CITY OF ALBUQUERQUE

June 11, 2015

Re: Andalusia Villas
5300 Antequera NW Buildings 7, 8 & 10
Request Permanent C.O. – Not Accepted
Engineer's Stamp dated: 1-18-14 (E12D15C)
Certification dated: 6-8-15

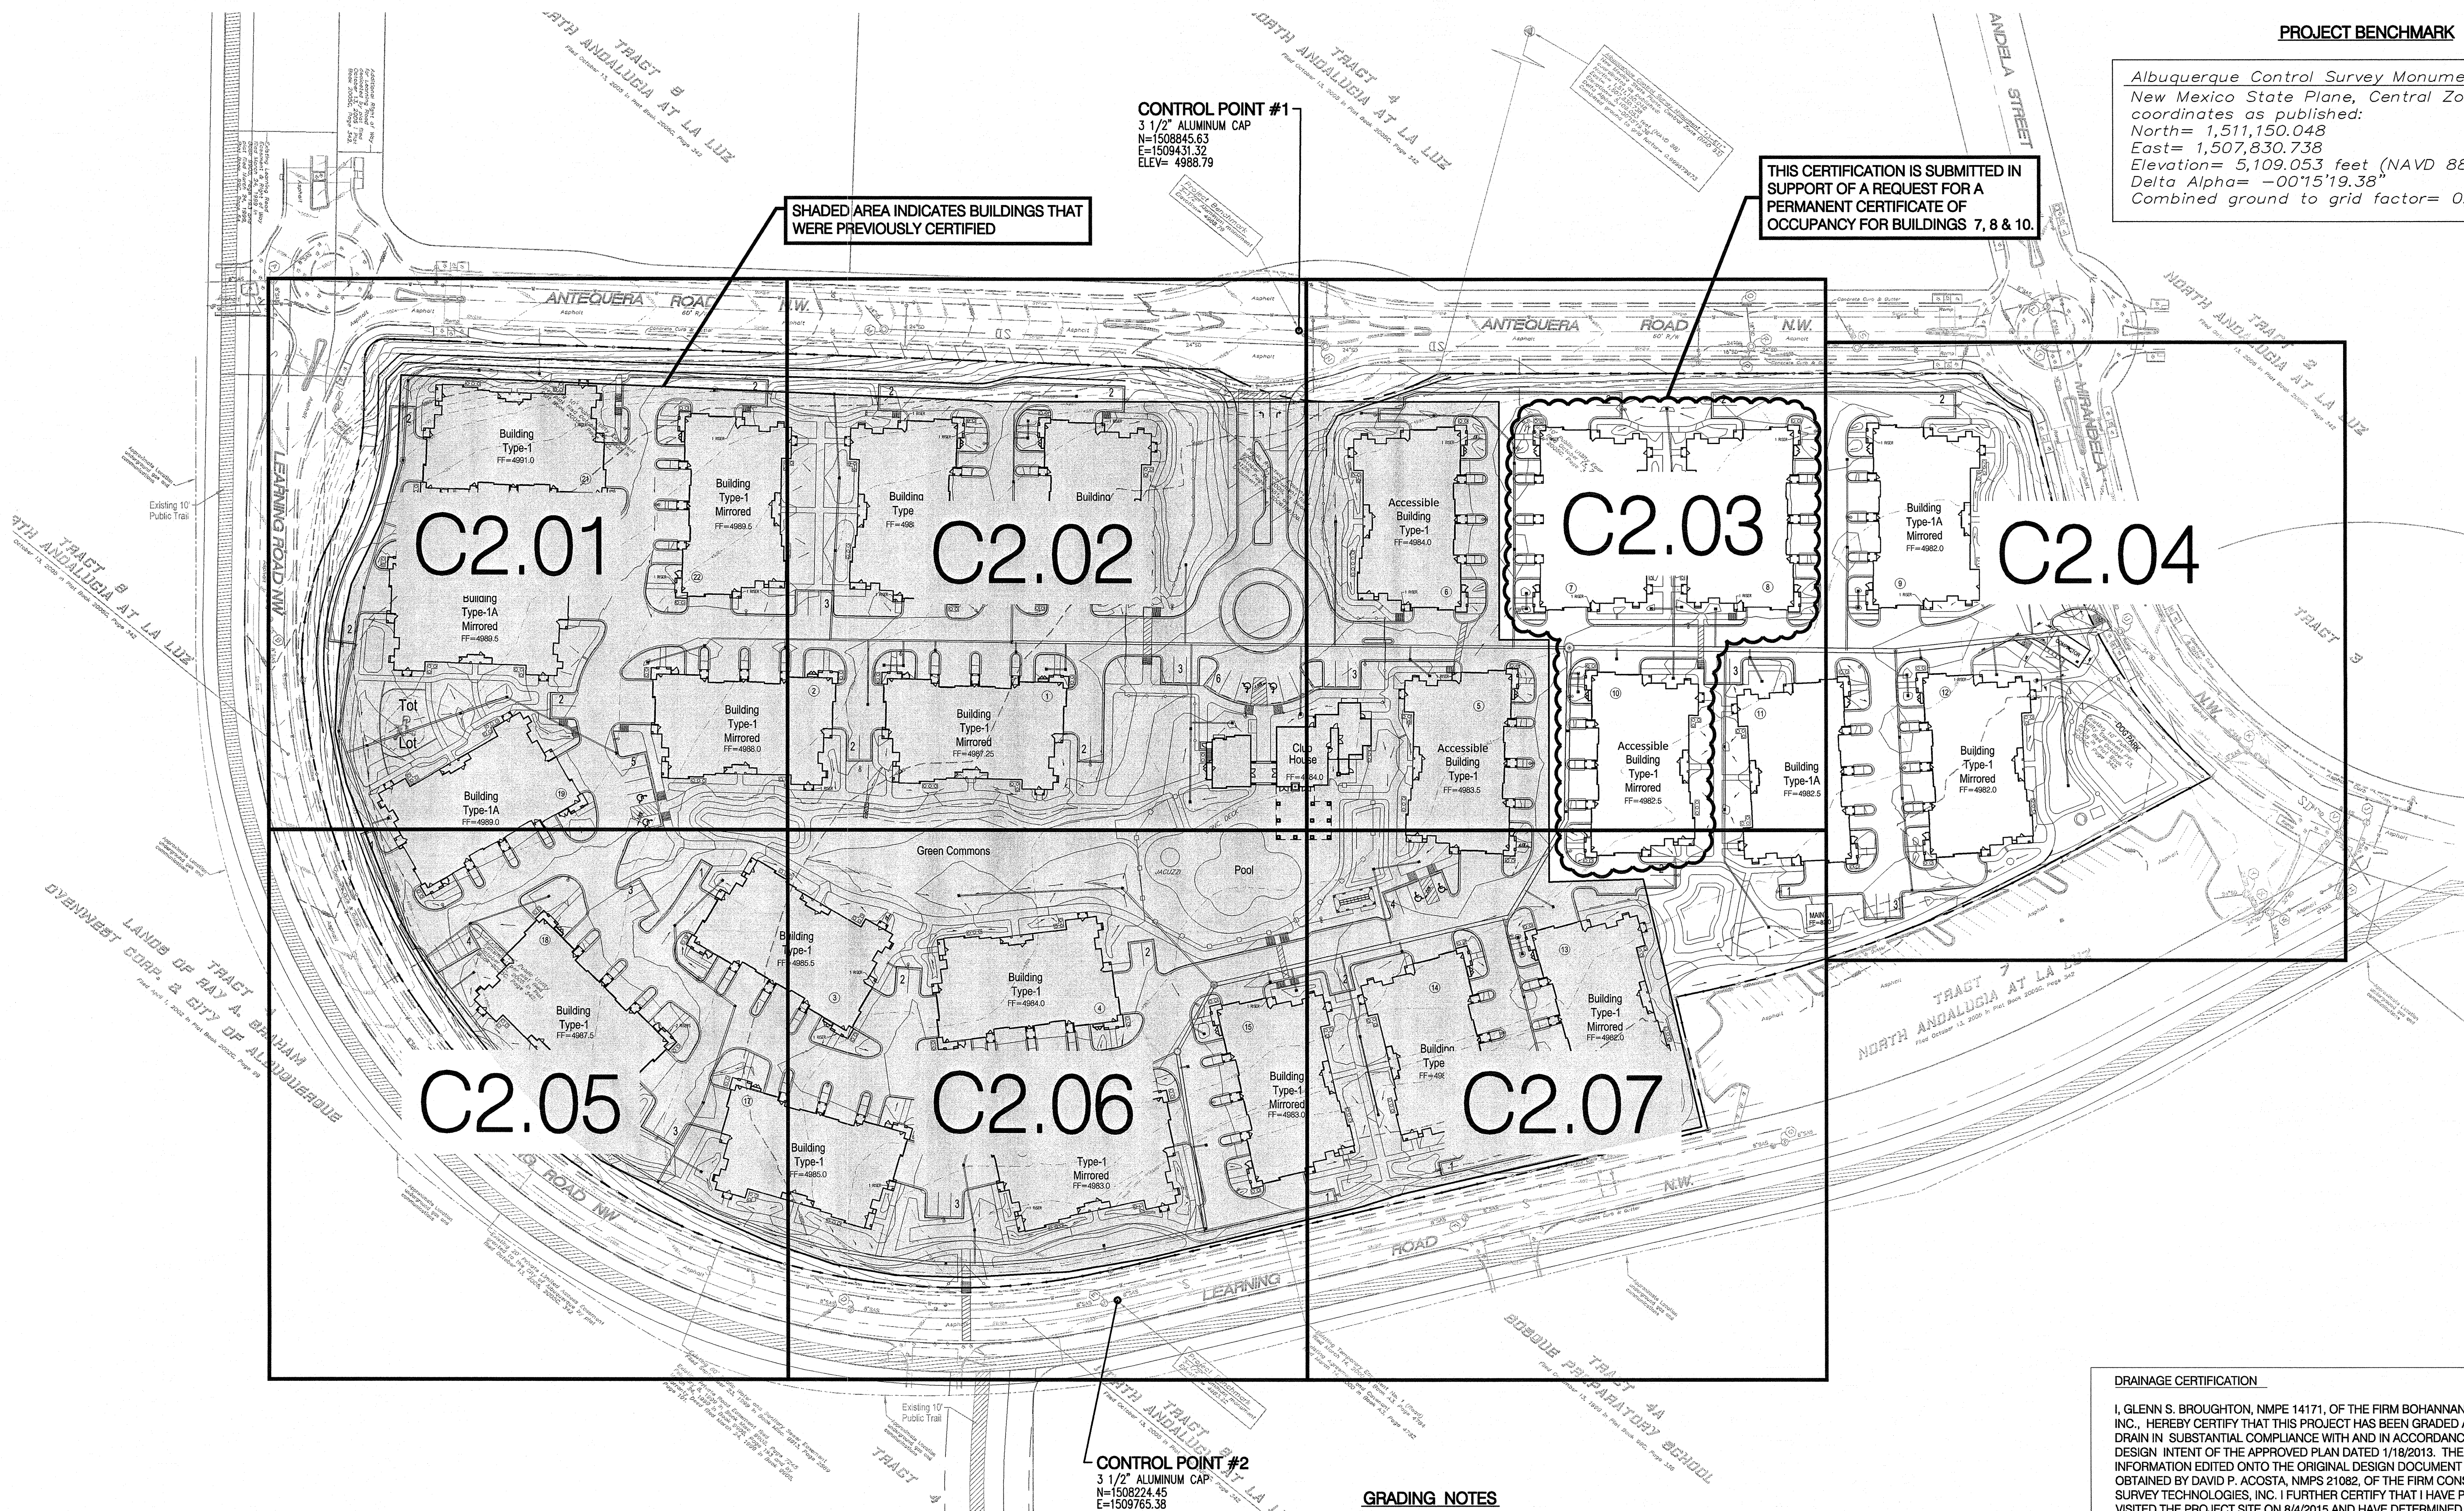
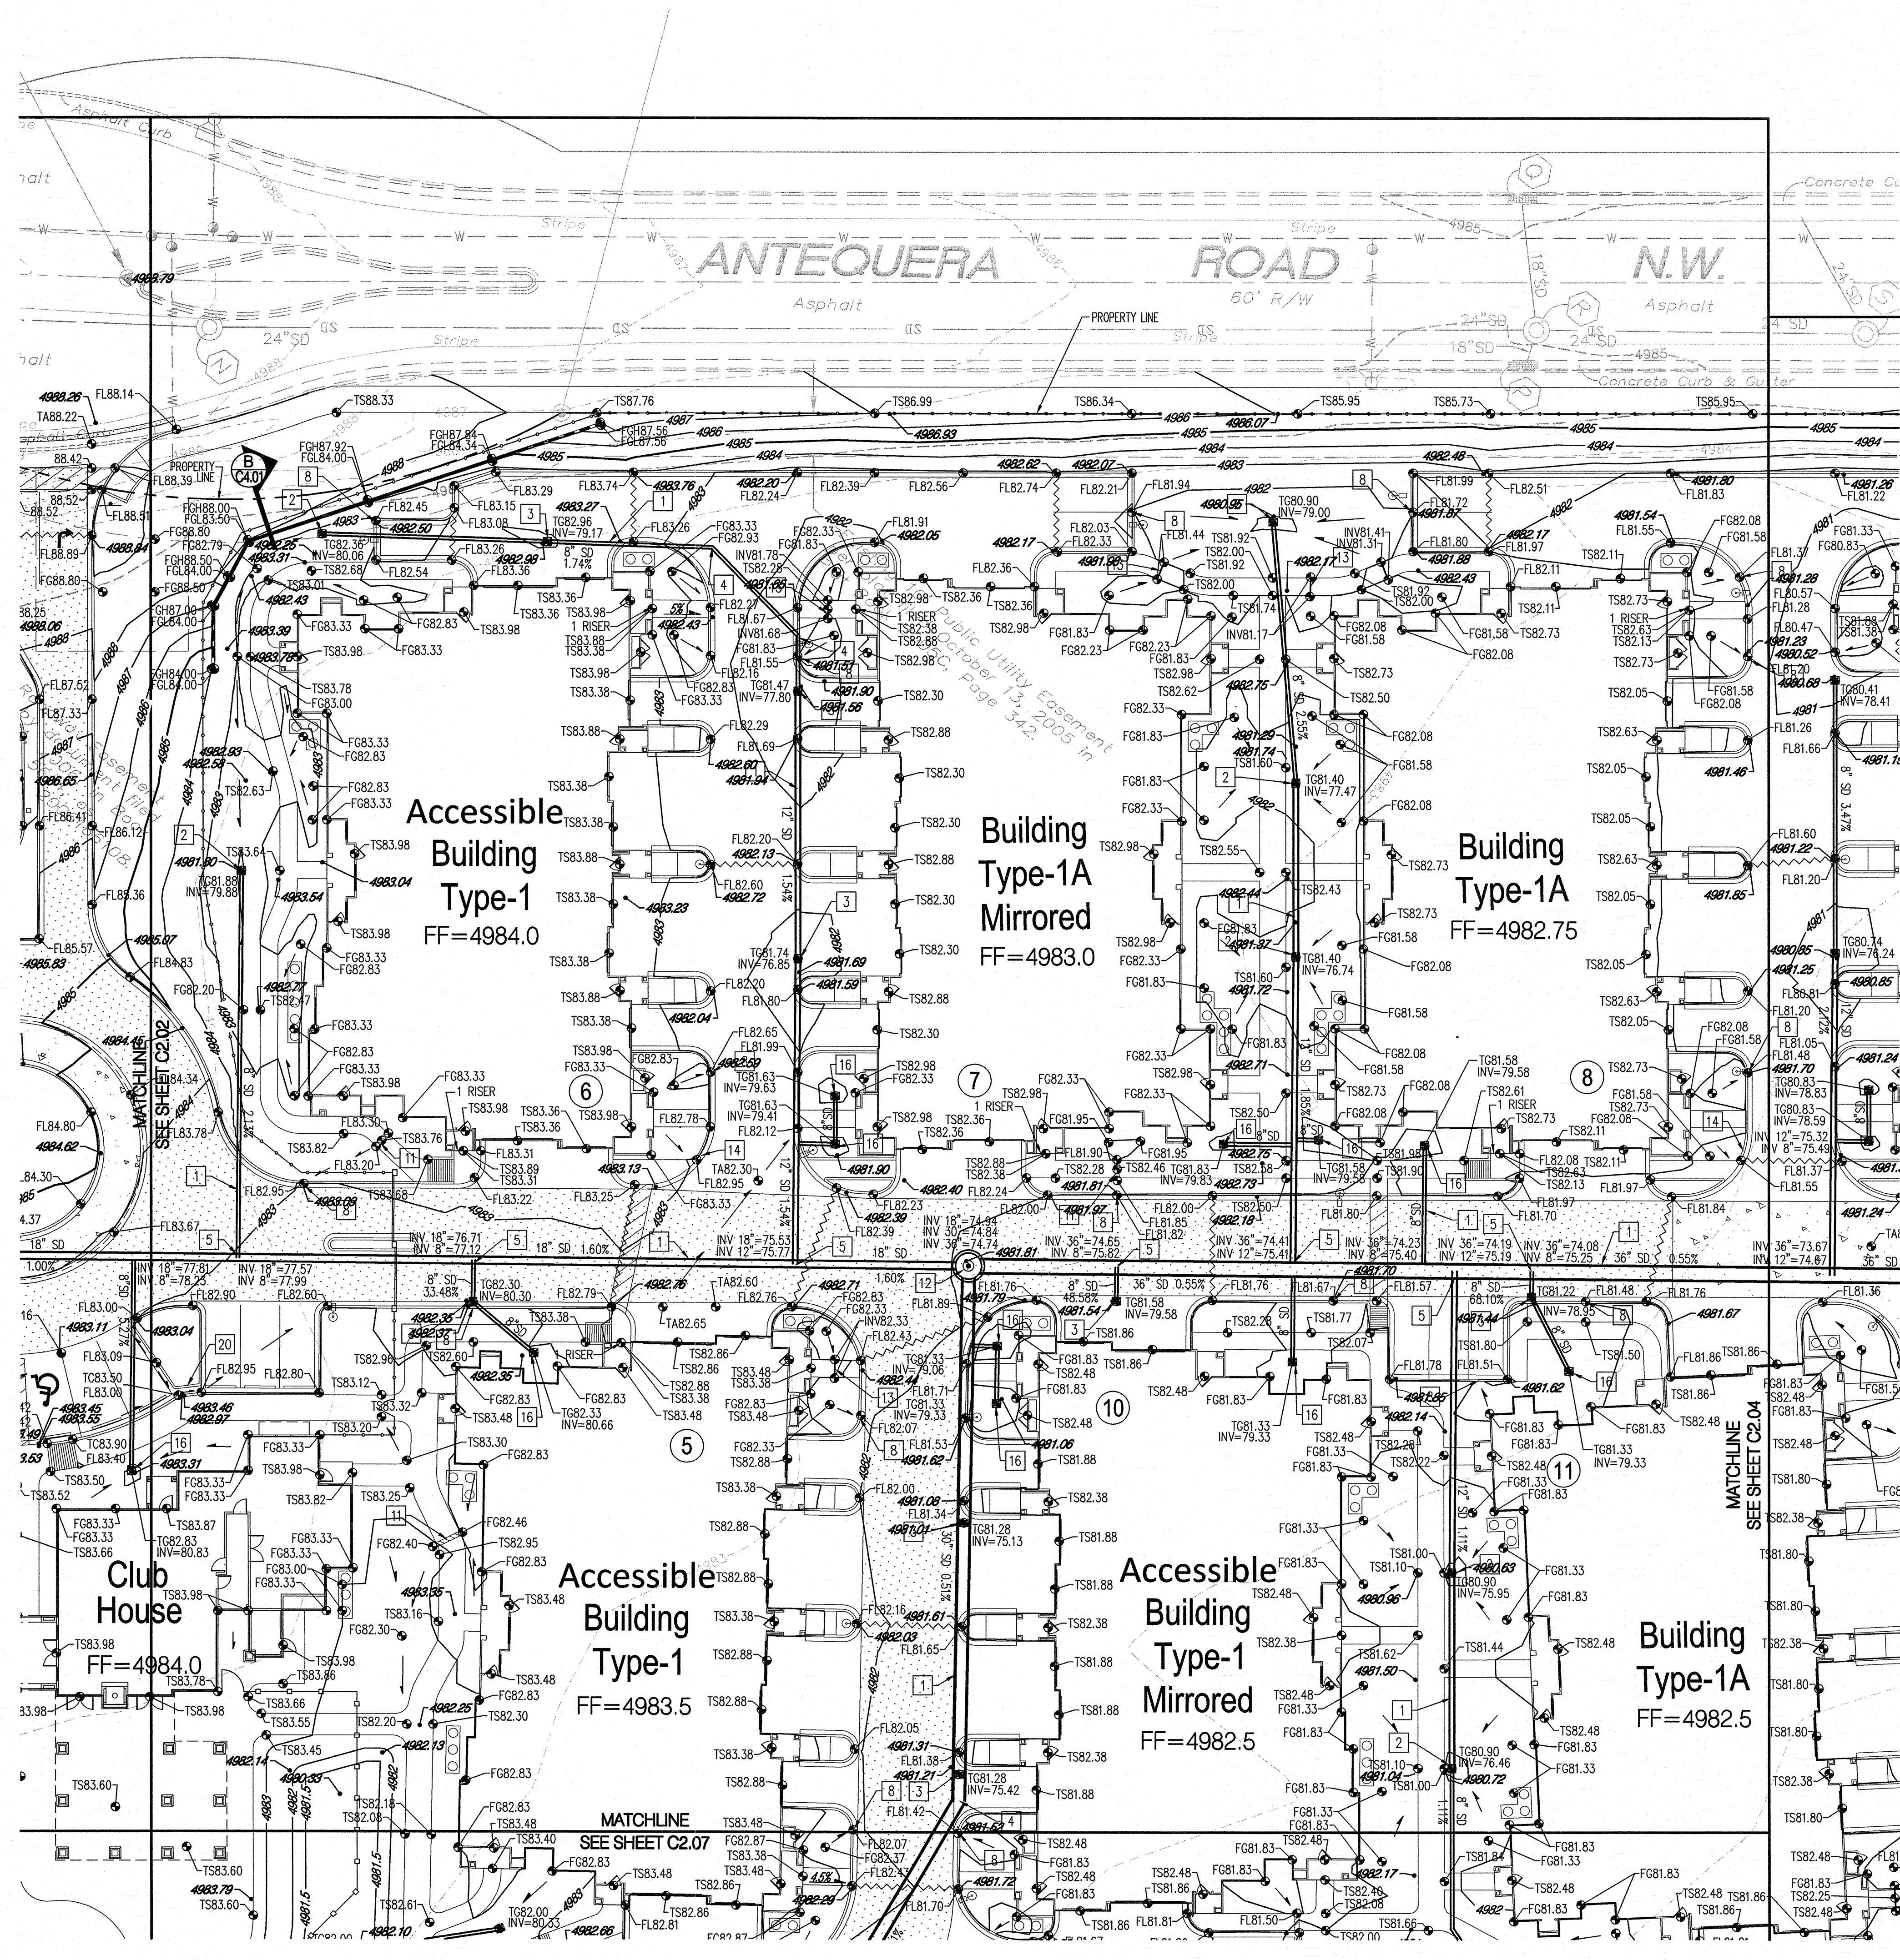
Based on the Certification received 6/10/2015, the site cannot be accepted for release of Certificate of Occupancy by Hydrology until the following comments are addressed.

- Three (3) inlets are missing.
- A manhole was relocated, need new inverts and reason why the relocation. How is maintenance going to be performed in the three way intersection of the storm sewer?
